OFFICIAL NOTICE OF DECISION

CITY OF ALBUQUERQUE
PLANNING DEPARTMENT
DEVELOPMENT REVIEW BOARD

Project# 1009843

13DRB-70792 VACATION OF PUBLIC ROADWAY EASEMENT
14DRB-70001 MINOR - PRELIMINARY/ FINAL PLAT APPROVAL
14DRB-70003 SUBDN DESIGN VARIANCE FROM MIN DPM STDS

PLAT OF  
**JASMINE SUBDIVISION**  
 SITUATE WITHIN  
**PROJECTED SECTION 18**  
**T.11N., R.4E., N.M.P.M.**  
**ELENA GALLEGOS LAND GRANT**  
**CITY OF ALBUQUERQUE**  
**BERNALILLO COUNTY, NEW MEXICO**  
 JANUARY 2014

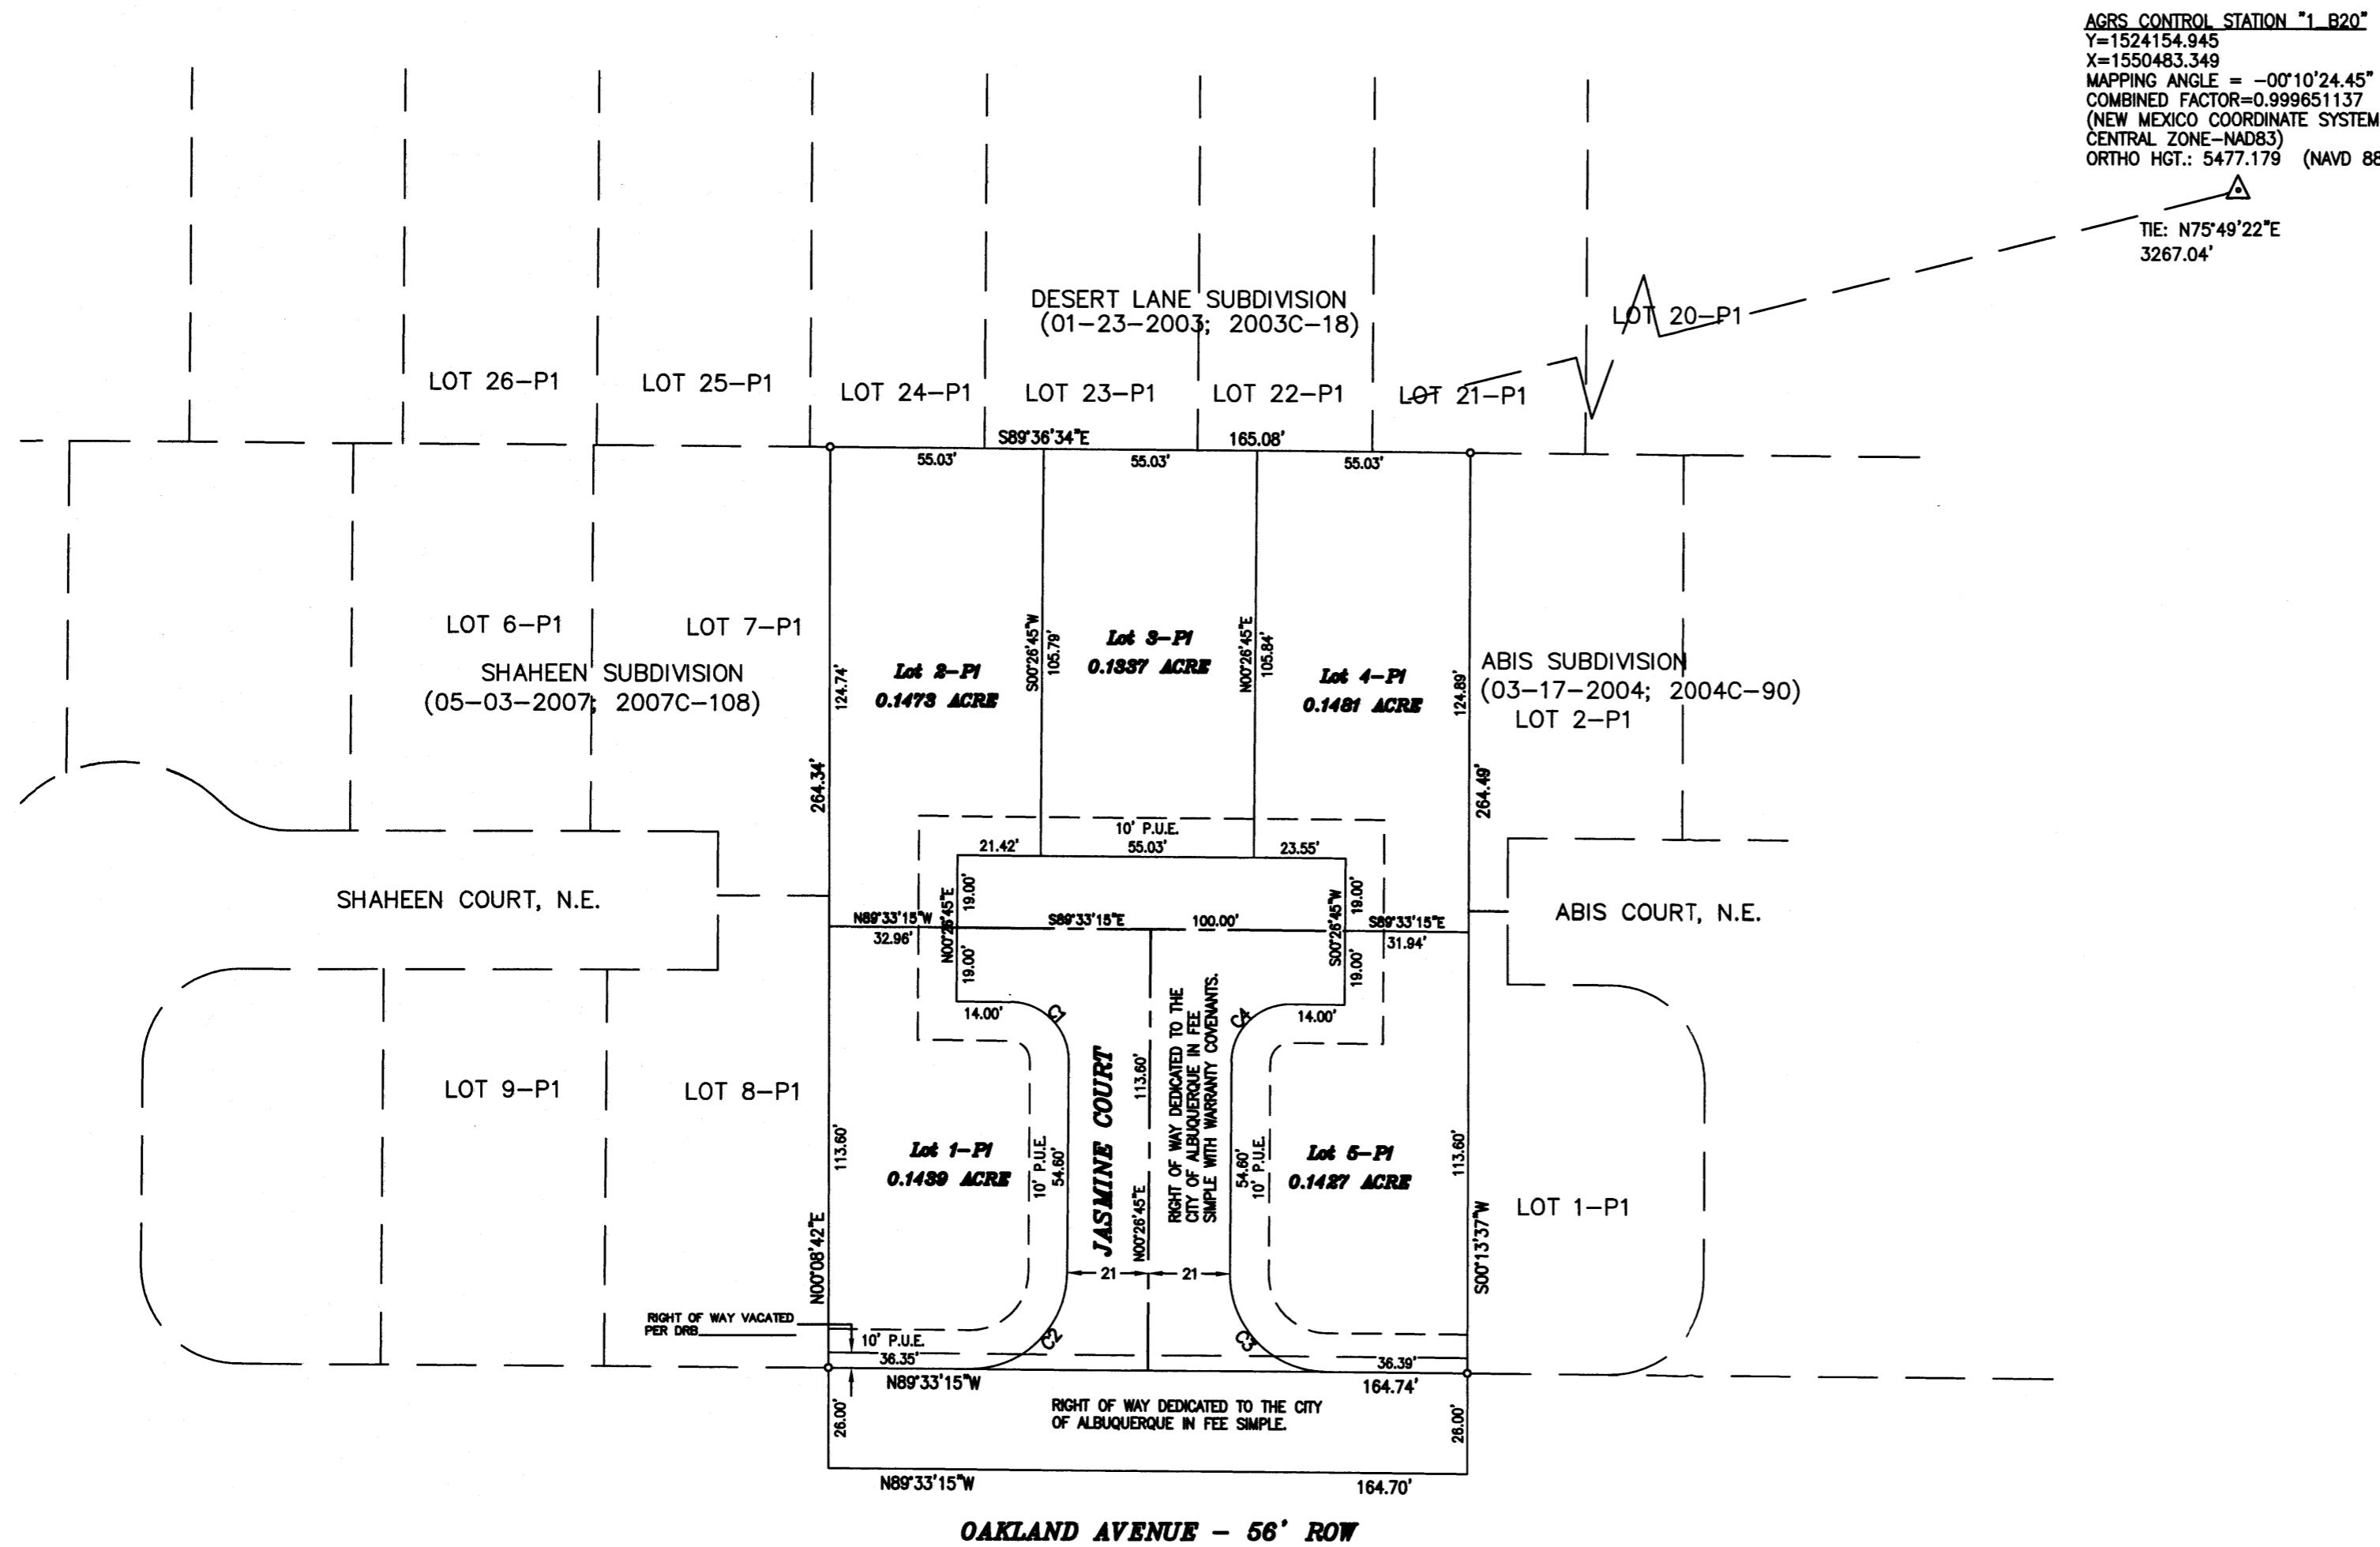
1. The vacated property shall be shown on a replat approved by the Development Review Board and the approved replat shall be filed for record with the Bernalillo County Clerk's Office within one year.
2. Zoning Note (5) shall be removed for the Final Plat.
3. The wall exhibit shall note a maximum height of 8 feet.

VACATION EXHIBIT

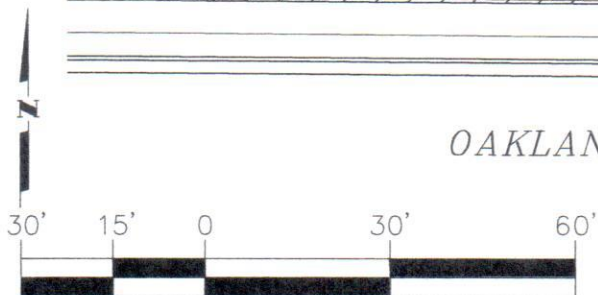
THE GROUP agents for LEGACY 18 request the referenced/ above action for approximately 4 ft of excess easement for OAKLAND AVENUE adjacent to Lot 20, Block 2, Tract 2, Unit 3, NORTH ALBUQUERQUE ACRES zoned R-D, located on the north side of OAKLAND AVE NE between SHAHEEN CT NE and ABIS CT NE. (C-19) [Deferred 1/15/14]

At the January 22, 2014 Development Review Board meeting, the vacation was approved as shown on Exhibit B in the Planning file per section 14-14-7-2(A)(1) and (B)(1)(3) of the Subdivision Ordinance.
